Application number: 2026/92192	
What is the application for?:	Change of use of residential dwelling (Use Class C3) to children's home accommod
Address of the site or building:	57, Adelphi Road, Marsh, Huddersfield, HD3 4BB
Postcode:	HD3 4BB

Type of comment: An objection	
Do you wish your comments to be published on the website anonymously?	Yes
I am writing to formally object to the above planning application. I live at 25 Wellfield Road, in the immediate vicinity of the application site, and am directly affected by the matters set out below. I understand this is a resubmission of application 2025/93550, which the Council refused on 16 March 2026 on safeguarding grounds, and whose subsequent appeal (PINS ref 6007912) was dismissed on 21 July 2026. My objection sets out both why the concerns that led to that refusal and dismissal remain unresolved, and additional local, first-hand concerns regarding the proposed security measures, parking, pedestrian safety and drainage that I do not believe have been properly addressed. 1. The locational safeguarding concern that led to refusal and dismissal of the appeal has not been addressed The Council's decision notice for application 2025/935

Project Title
proposed site plan

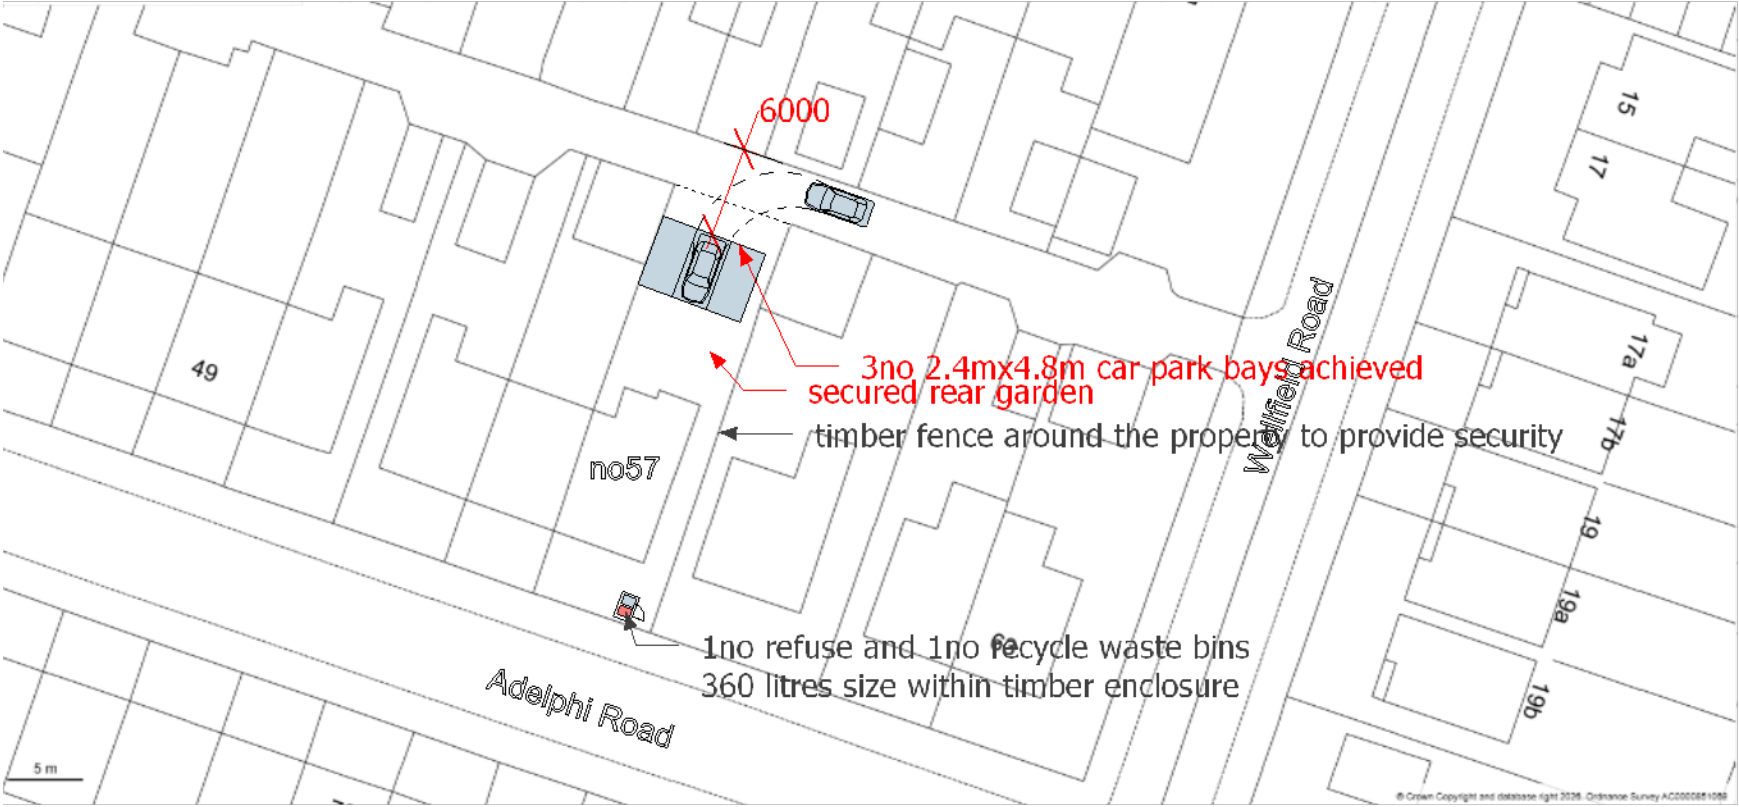
I would also ask the Council to satisfy itself that the security measures described are coherent and genuinely deliverable, rather than being asserted in supporting text alone. The submitted Proposed Site/Block Layout drawing labels the rear yard, which is also shown as providing three car parking bays, as a 'secured rear garden' with a 'timber fence around the property to provide security.' This is a description of what the applicant proposes to install, not of the property's current condition: based on my own first-hand knowledge of the site, no such perimeter fencing or rear security currently exists. I supply photographic evidence of the site's current condition separately in support of this objection. As the safeguarding case for this application appears to rely in part on this proposed security package, I would ask the Council to require the applicant to confirm precisely what boundary treatment and access control is to be installed, when, and how it would be reconciled with regular vehicle movements in and out of the parking area, and, if planning permission were to be granted, to secure this by way of a pre-occupation planning condition rather than accept it as already in place.
